TO: Jean Fraser, Planner
FROM: David Senus, P.E. & Ashley Auger, E.I.T.
DATE: December 2, 2013
RE: 118 on Munjoy Hill, Level III Site Plan Review

Woodard & Curran has reviewed the Level III Site Plan Application for the development project located at 118 Congress Street in Portland, Maine. The project will involve the construction of a new four story mixed-use building consisting of residential units and retail space.

Memo To: Jean Fraser
Barbara Barhydt
From: David Margolis-Pineo
RE: Development Review Comments for 118 Congress St.

1 NORTH ELEVATION
1/8" = 1'-0"

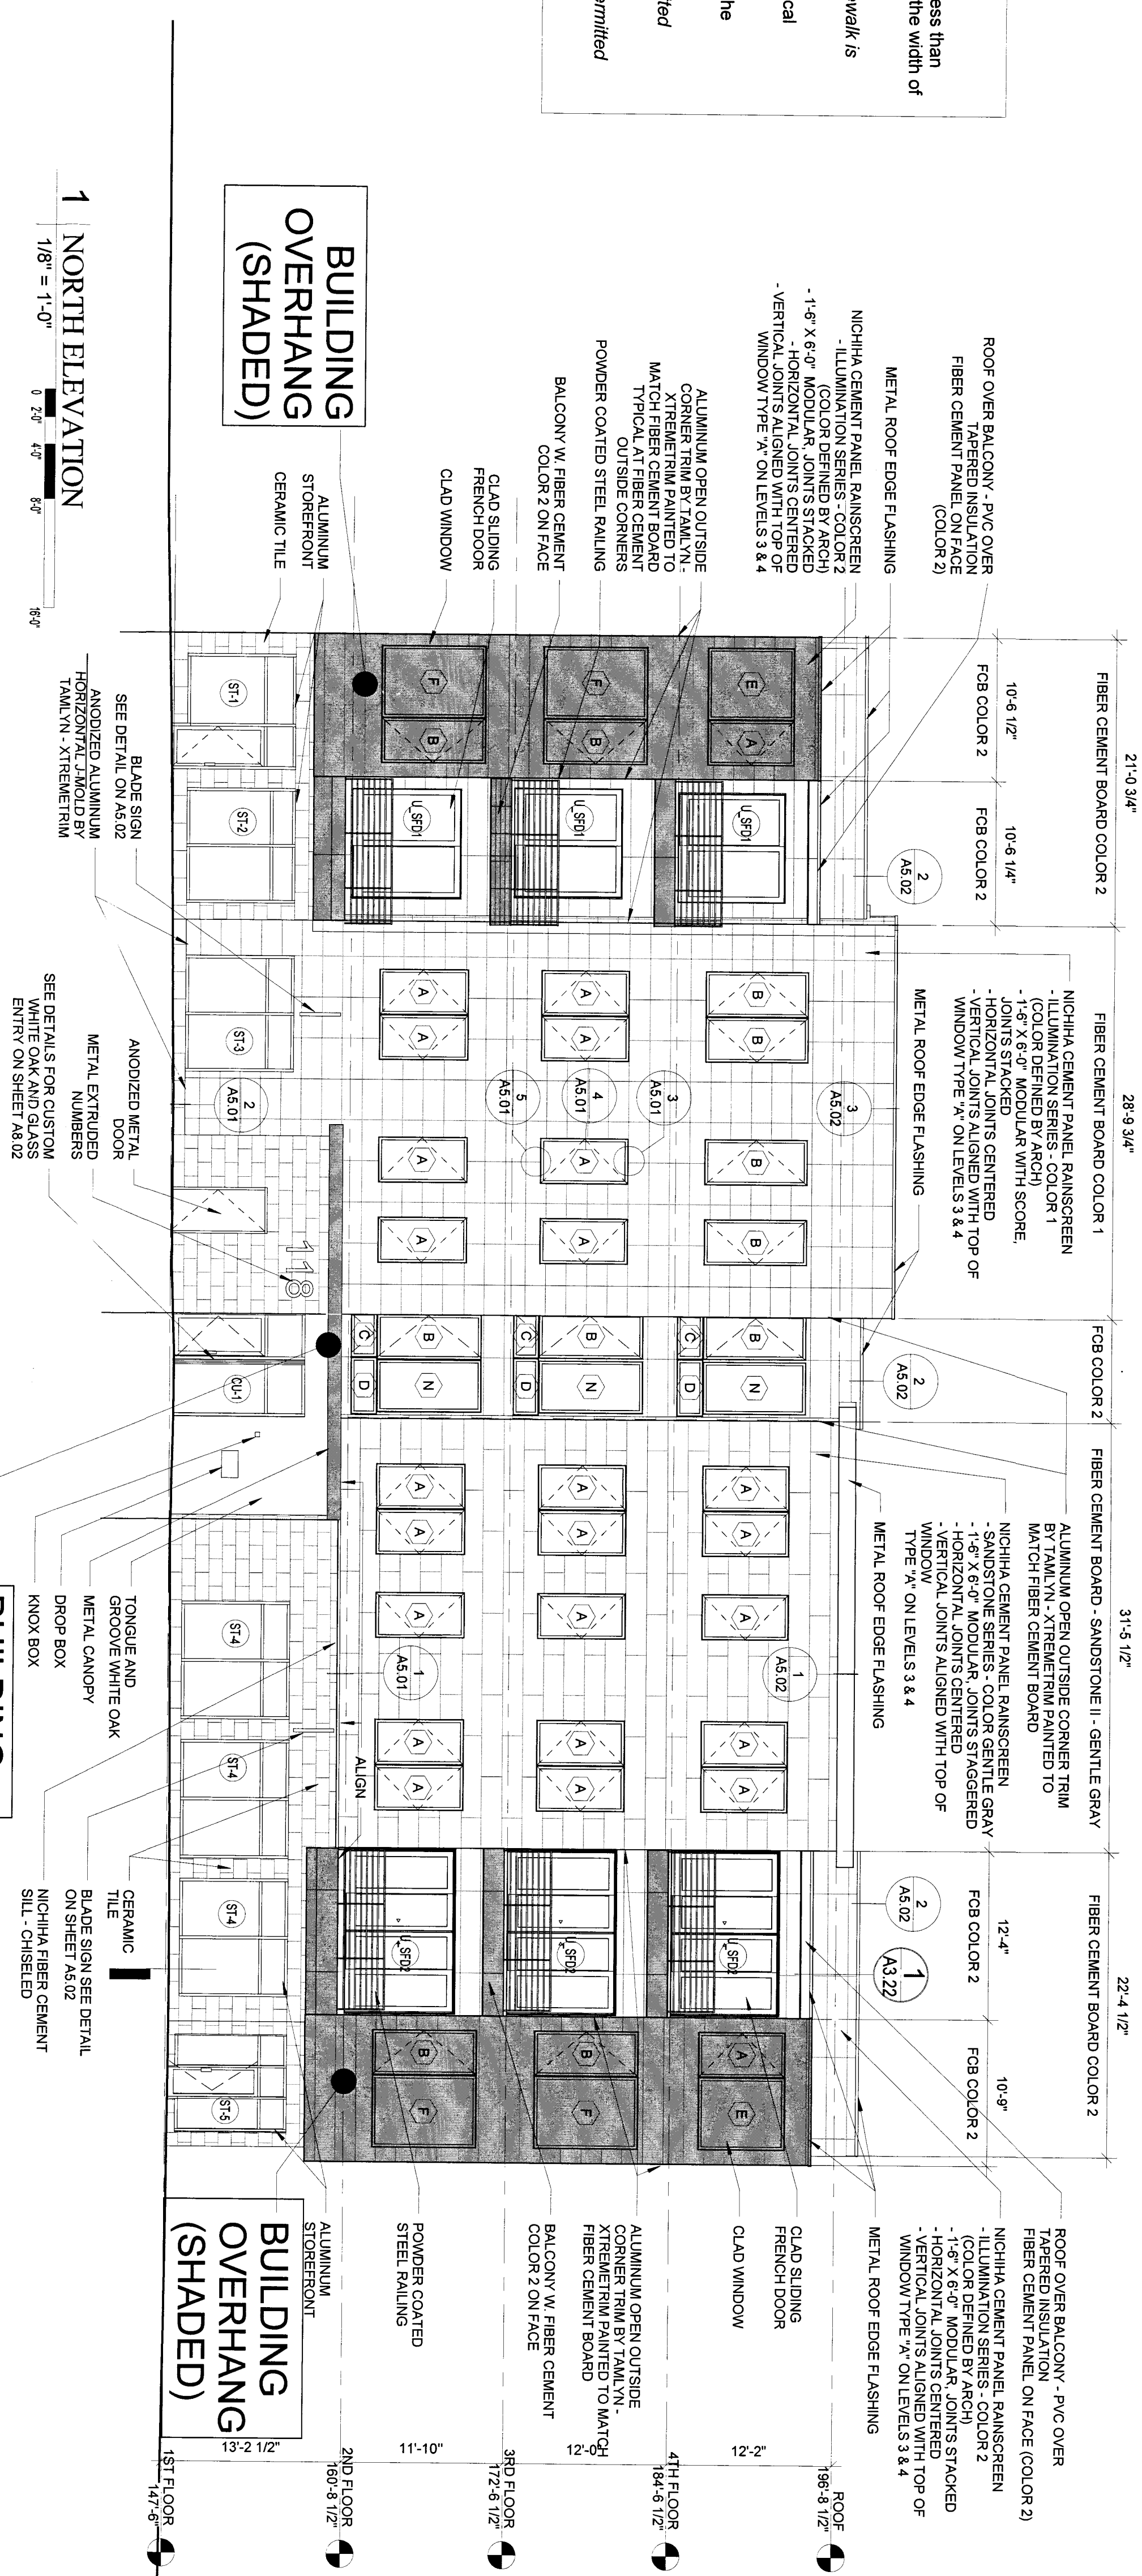
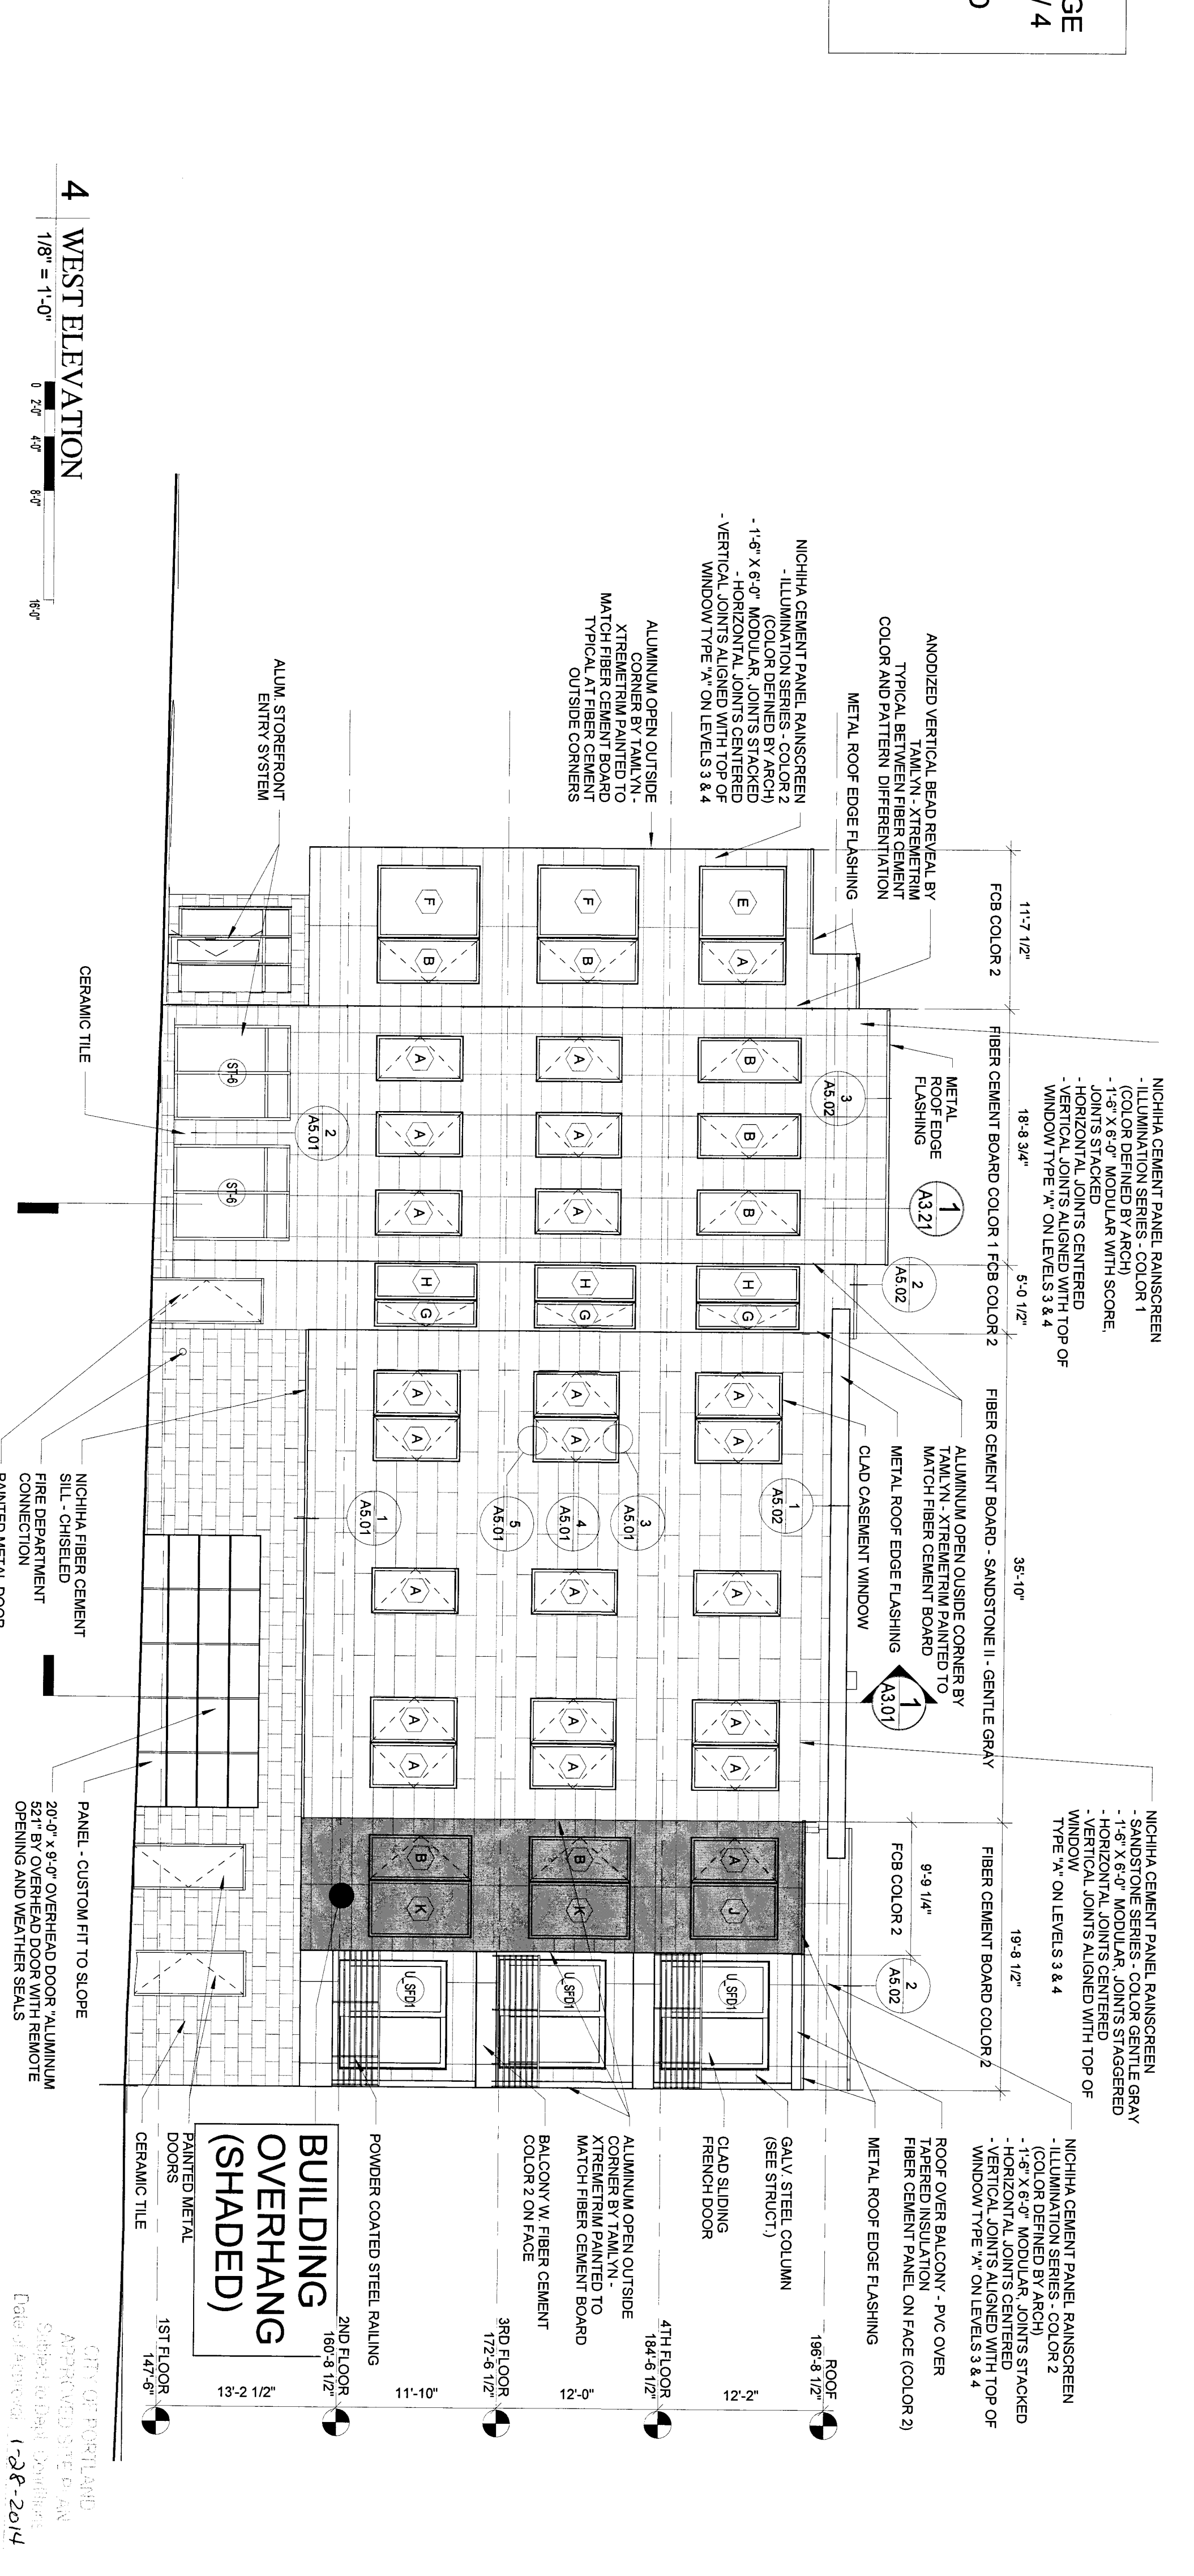
5. A city license will also be required for all proposed portions of the building overhanging the street right of way. The proposed areas encroaching into the Congress and St Lawrence St right of way are excessive and should be scaled back or the building should be set back to accommodate these features. Falling ice and snow is a pedestrian safety issue.

In regards to the architectural elements proposed to overhang the public right of way, unlike other exceptions where this kind of easement over the right of way was granted, this project is not limited by site constraints, existing structure, or by maintaining historical character. When weighing the impact of this aspect of the project on the public realm the following conclusions were reached. The articulation of the facade is a benefit to the streetscape and produces a good design that meets the design standards. However, the size of the lot would not preclude the articulation from occurring within the property line. In fact, the neighboring houses appear to be set back from the property line a foot or two to accommodate bay windows and/or porch steps. Stepping the retail facades back a foot or two would not negatively affect the street wall. Another possible detriment to the public includes the drip line of the overhangs onto the pedestrian path which could result in safety and comfort concerns. The protruding bays and balconies will also interfere with the growth and placement of street

trees, and therefore reduce the quality and benefit of the right of way to the public. And finally, there is some concern about the affect on the public views to the Observatory. I would request renderings that look straight up and down Congress Street to understand how far into the view corridor the balconies project and how it affects view corridors.

2 BRICK DRIVEWAY APRON WITH BITUMINOUS BASE (1-11)
NOT TO SCALE

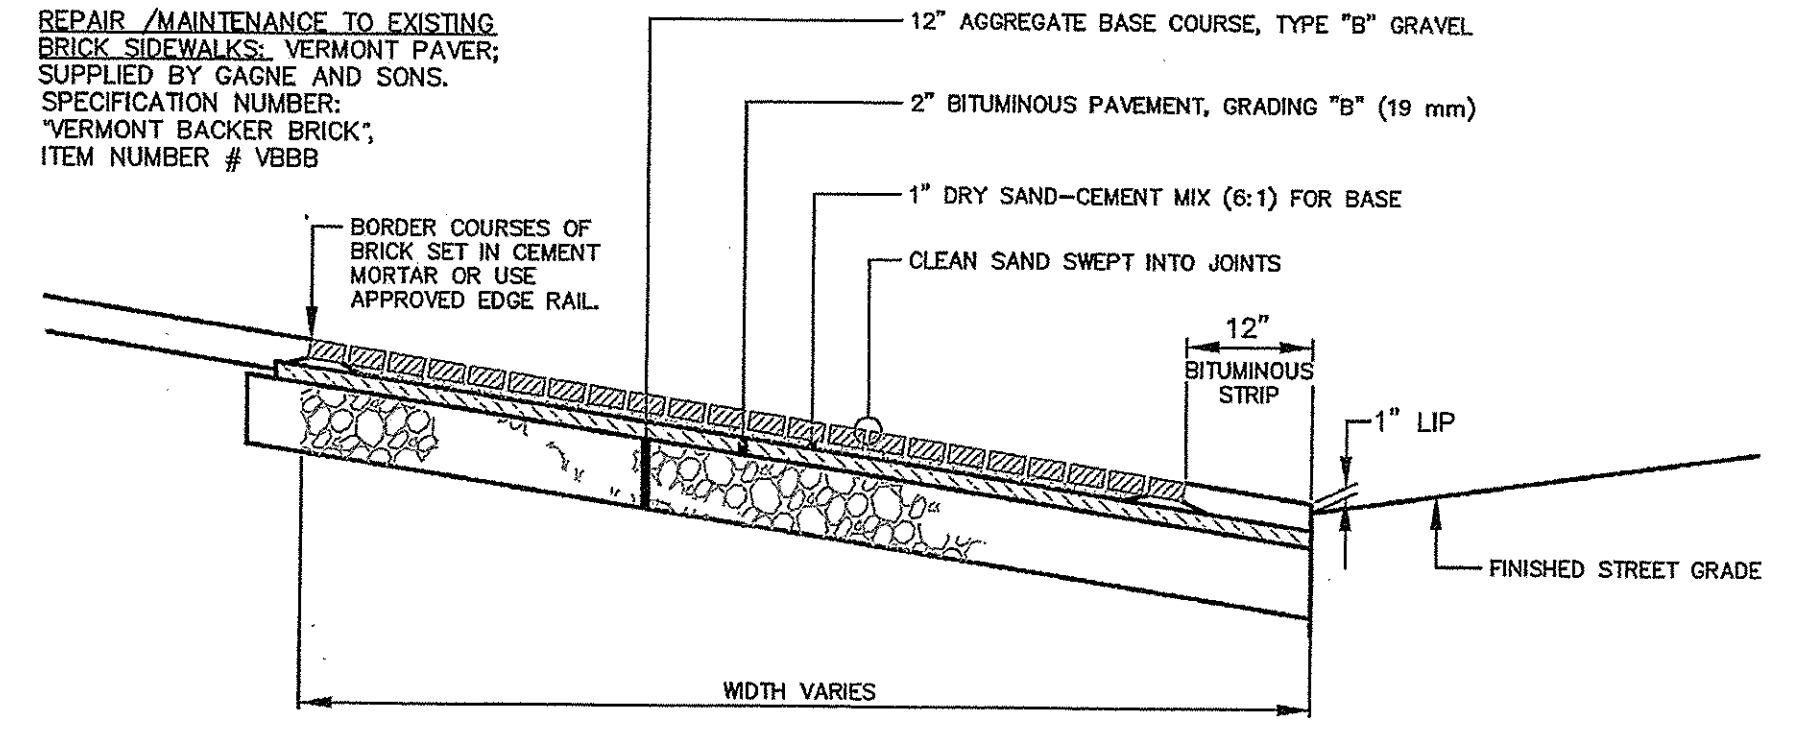
6. The proposed back deck encroaches the required set back.
7. The proposed curb cut currently shows a brick apron. The City's Technical Manual requires asphalt drive aprons.

1 CITY OF PORTLAND BRICK SIDEWALK/CURB DETAIL
L2.0 NOT TO SCALE

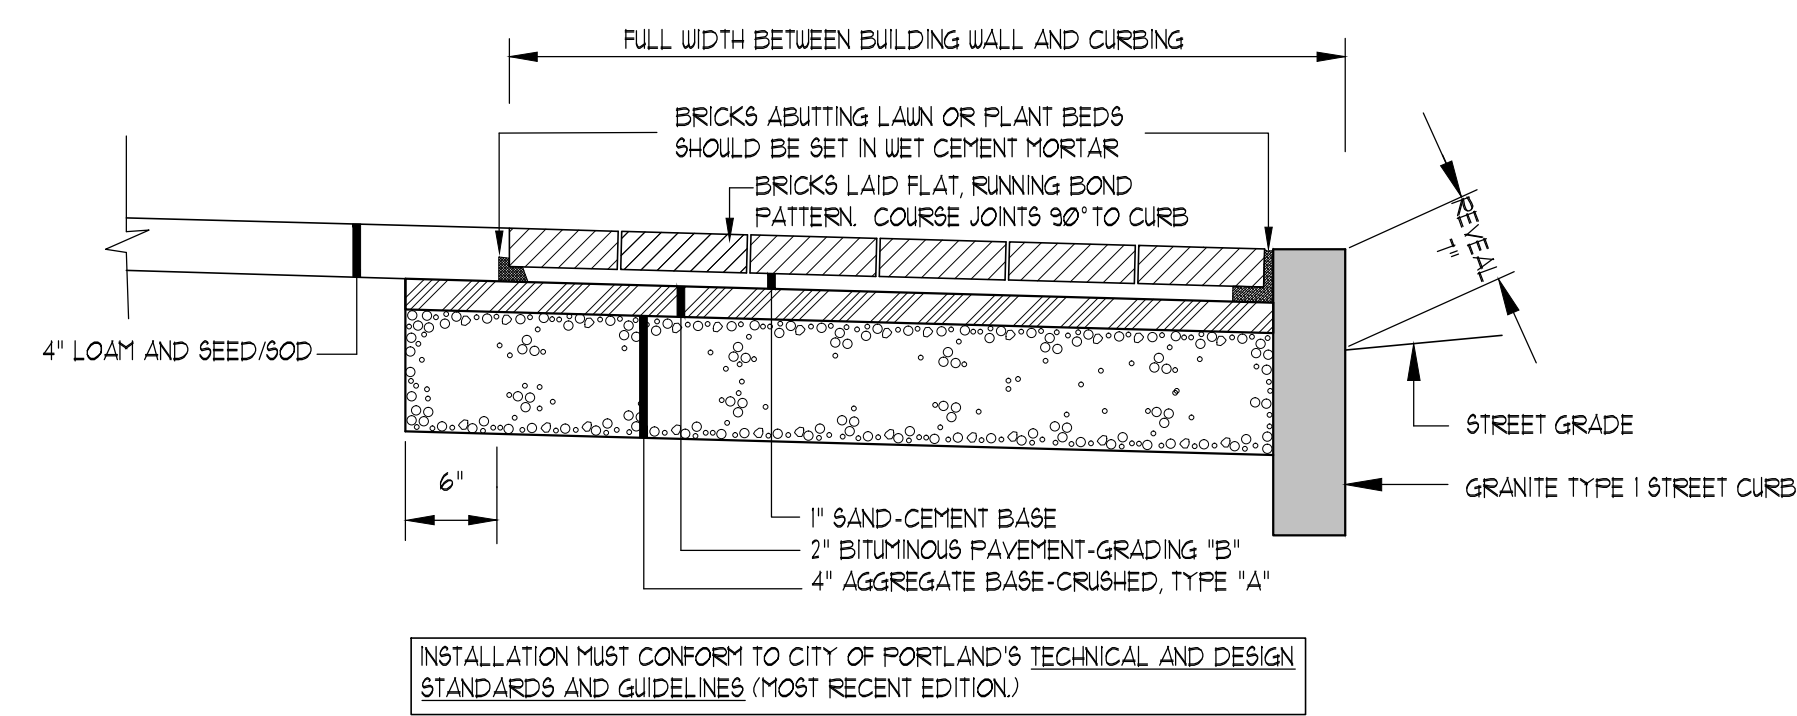
- 3) The following details should be added for work within the City Right-of-Way in accordance with the City of Portland Technical Manual:
 - a) Brick Sidewalk
